DOC20/501026

24 June 2020

**Redfern Station Upgrade – New Southern Concourse (SSI 10041)  
Advice on Environmental Impact Statement (EIS)**

Figure 11 | Noise catchment areas (NCA) (Source: EIS)

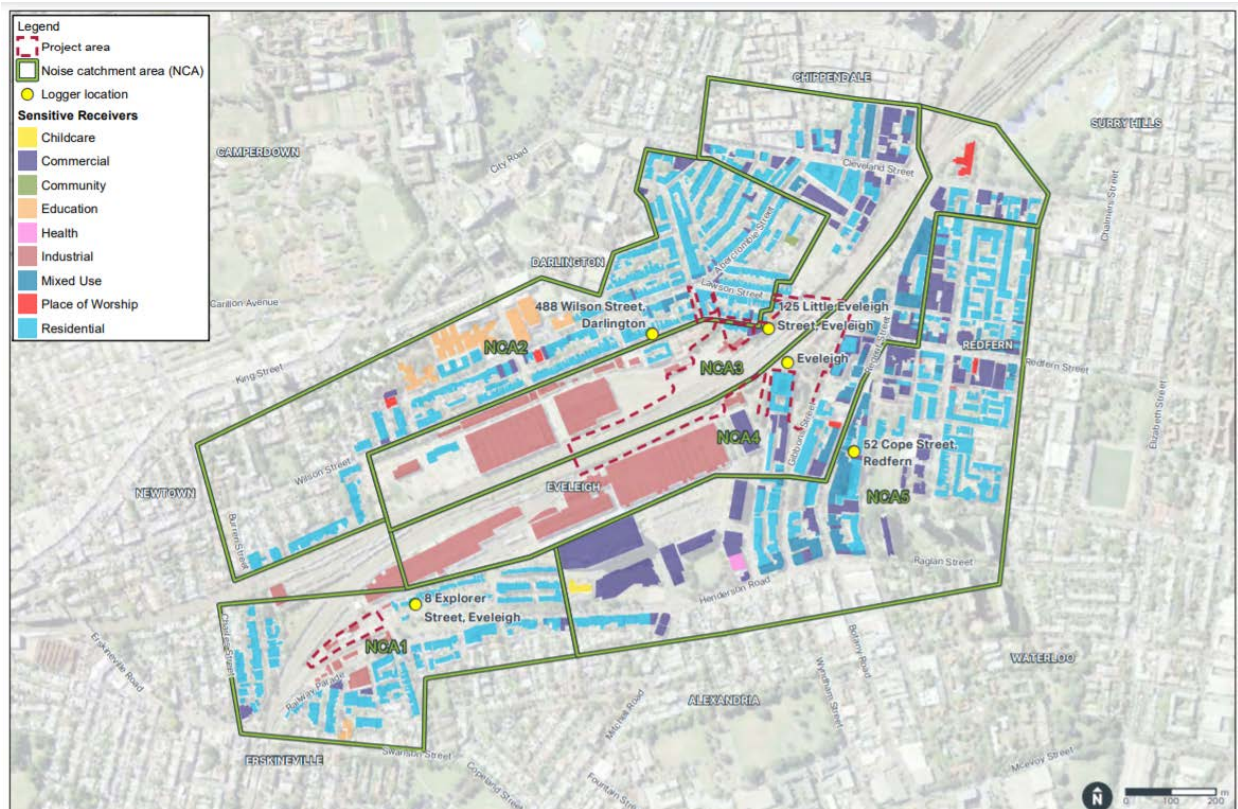
Furthermore, it is recommended that community engagement is undertaken to inform noise-sensitive receivers about the work, when it will take place, and for how long. Engagement is particularly important for the NCA1 location if the adjacent auxiliary facility is to be installed. The community that resides within NCA1 should be told as soon as possible if the auxiliary facility will be required. The advice in CNVS on community engagement strategies should be implemented as appropriate.
